M25 junction 28 improvement scheme

TR010029

9.28 Schedule of Changes to draft Development Consent Order

**TR010029/EXAM/9.28(2) SCHEDULE OF PROPOSED AMENDMENTS TO THE DRAFT
DEVELOPMENT CONSENT ORDER (dDCO) AS REVISED FOR DEADLINE 4**

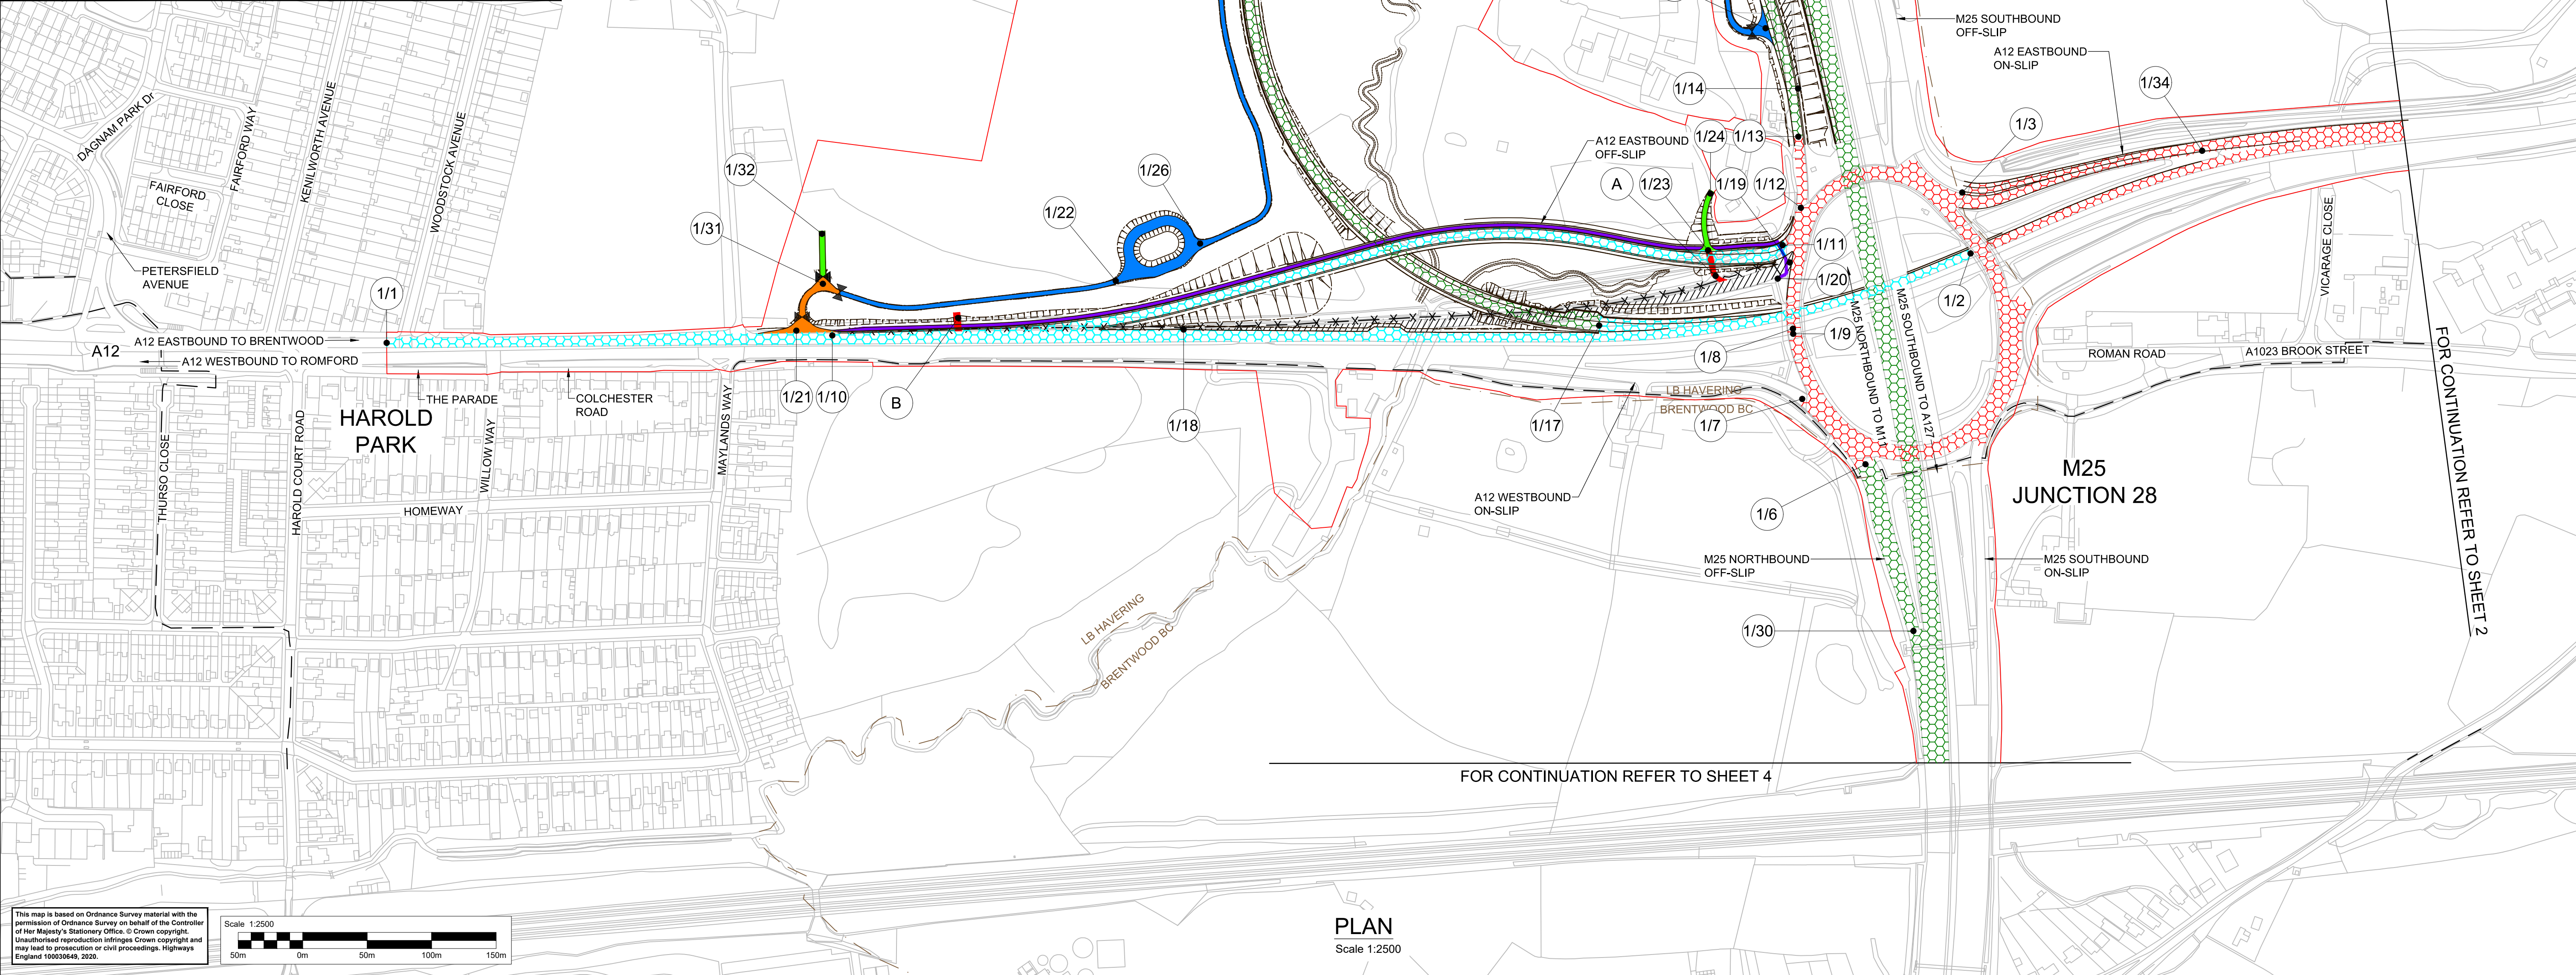
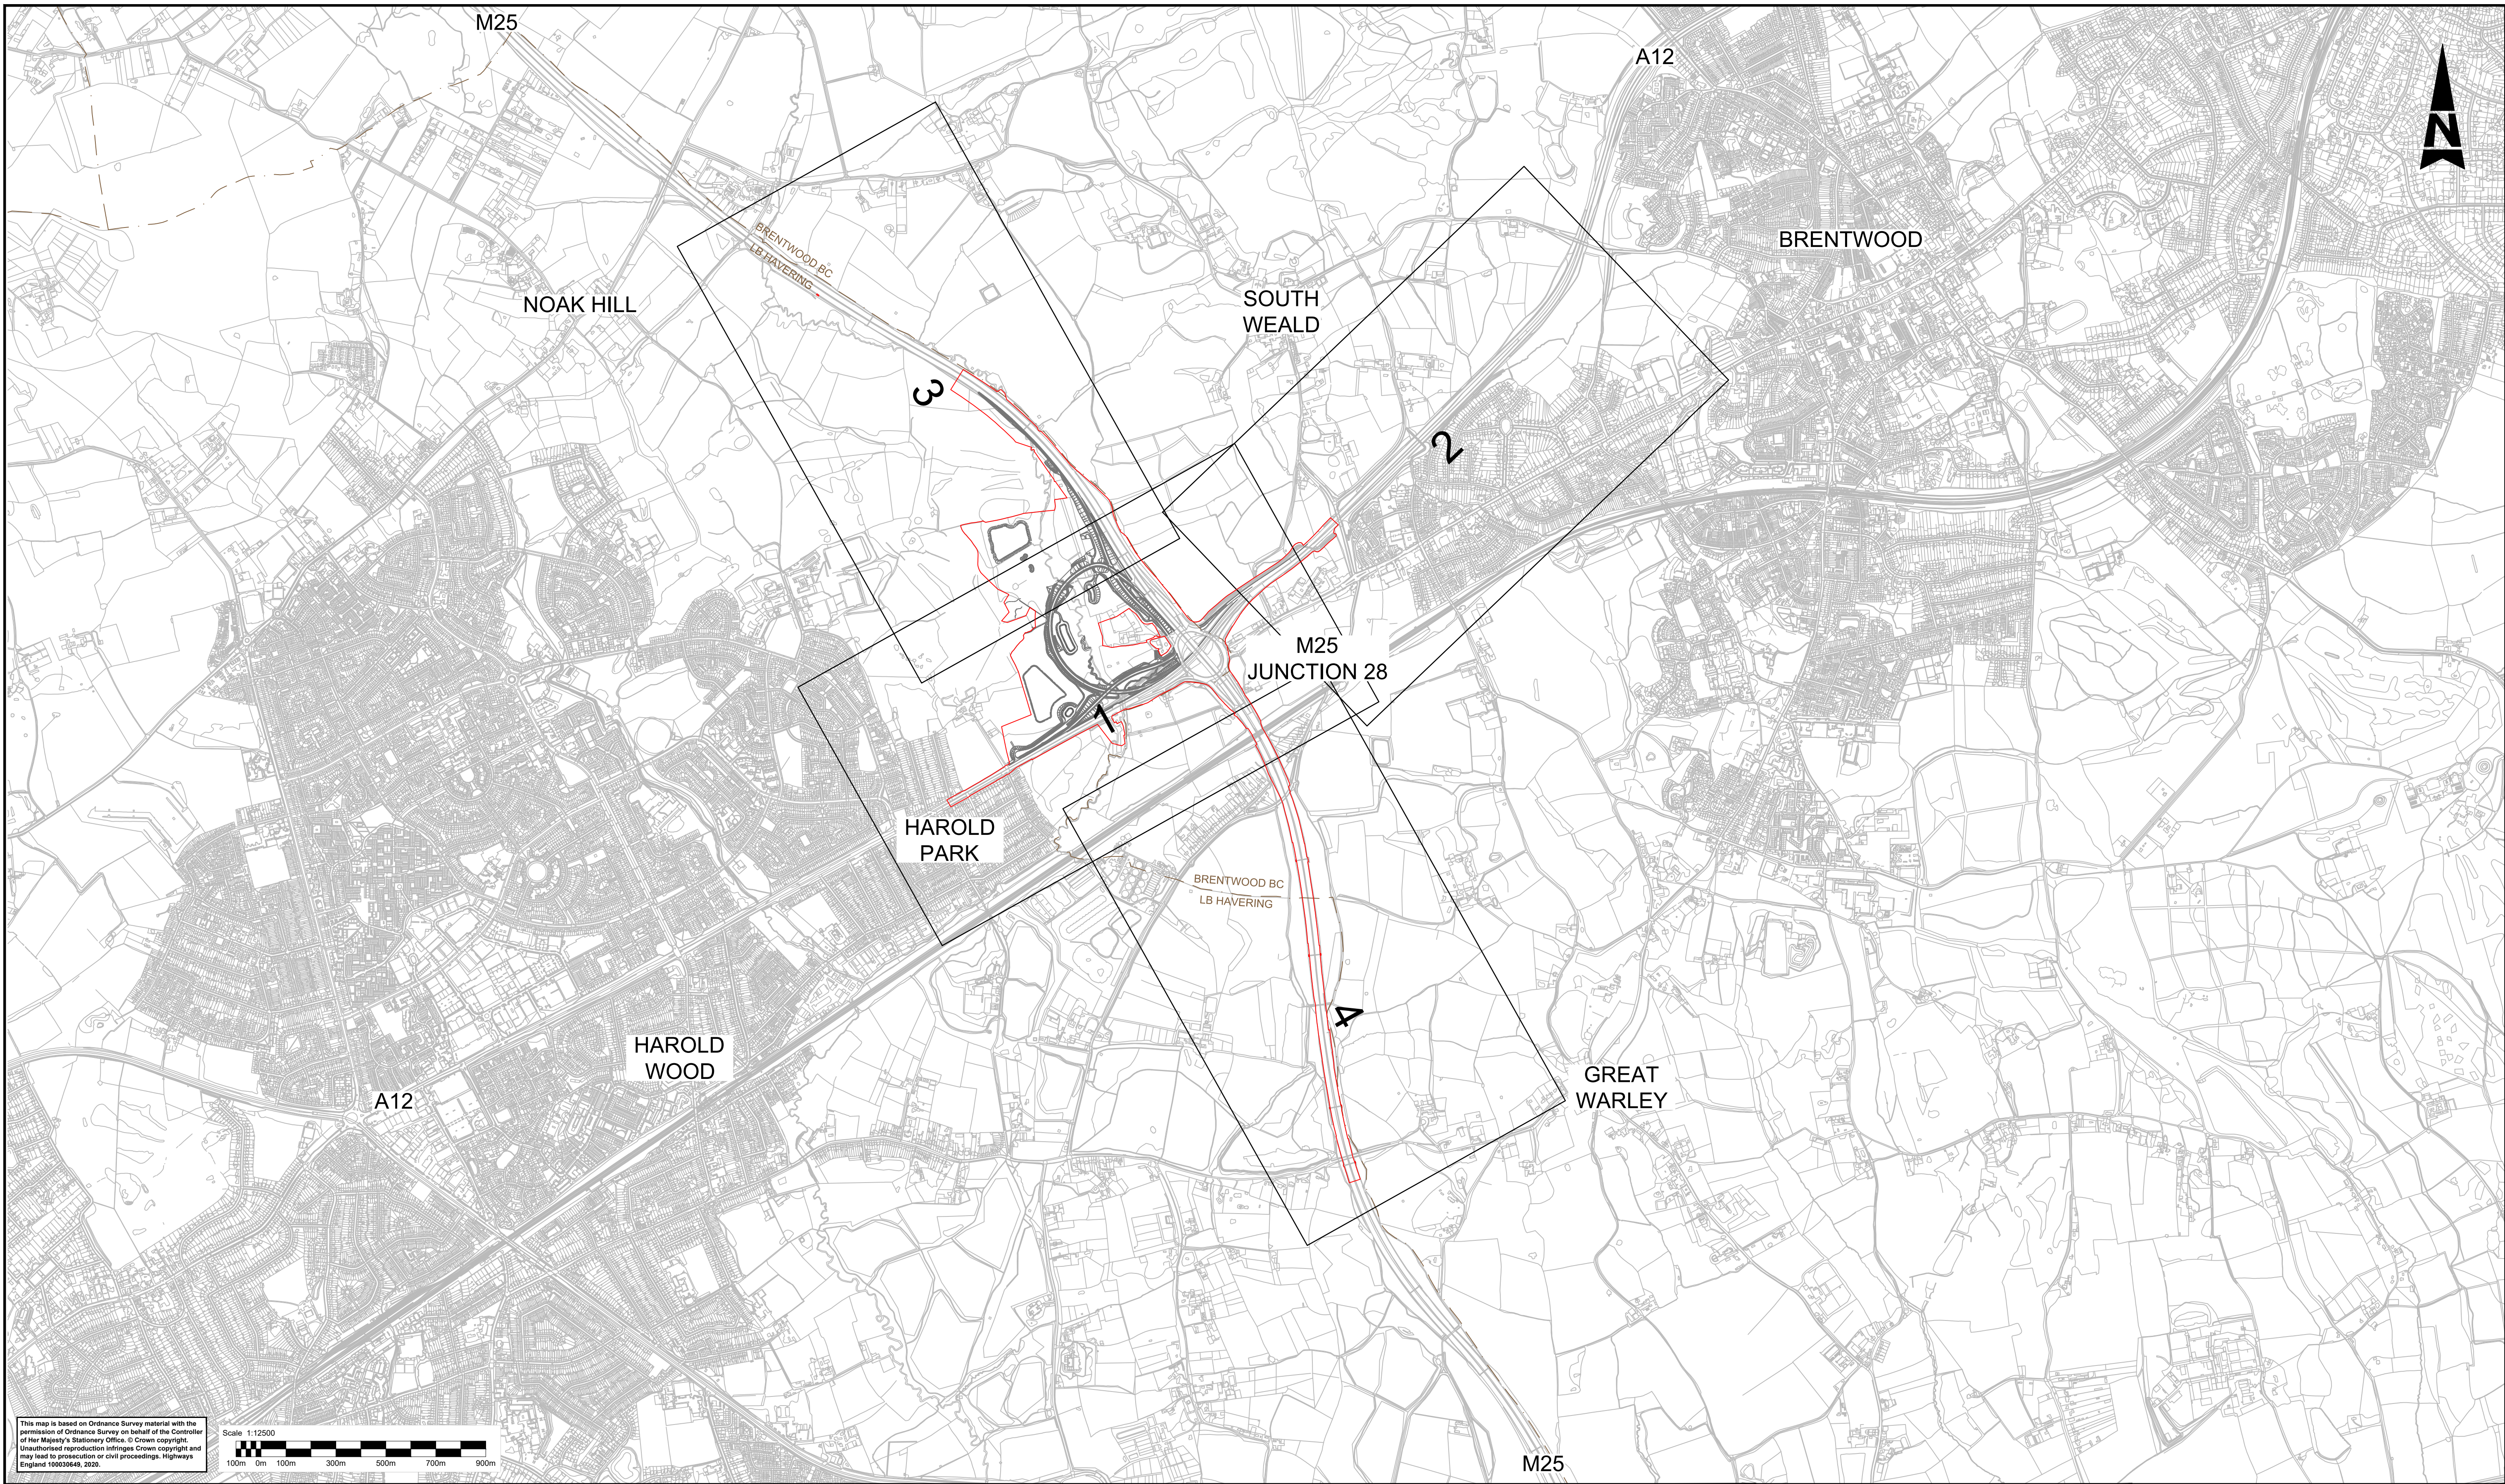
15.	Schedule 4 Part 2 (Transport for London Road Network)	<p>(1) <i>Highway</i></p>	<p>(2) <i>Extent</i></p>	Deleted following submissions made by TfL that this was not needed as the A12 is already so designated.
		A12 Eastbound	Between points 1/1 on Sheet 1 to 1/2 on sheet 1 of the streets, rights of way and access plans

16.	Schedule 4 Part 3 (Trunk Roads)	<p>(1) <i>Highway</i></p>	<p>(2) <i>Extent</i></p>	Plot removed
		M25 Junction 28, circulatory carriageway	Entire M25 Junction 28 circulatory carriageway linking points 1/3, 1/6, 1/7, 1/8,

No	Provision	Suggested amendment			Explanation for change
		4/9, 1/11, 1/12 and back to 1/3 on sheet 1 of the streets, rights of way and access plans
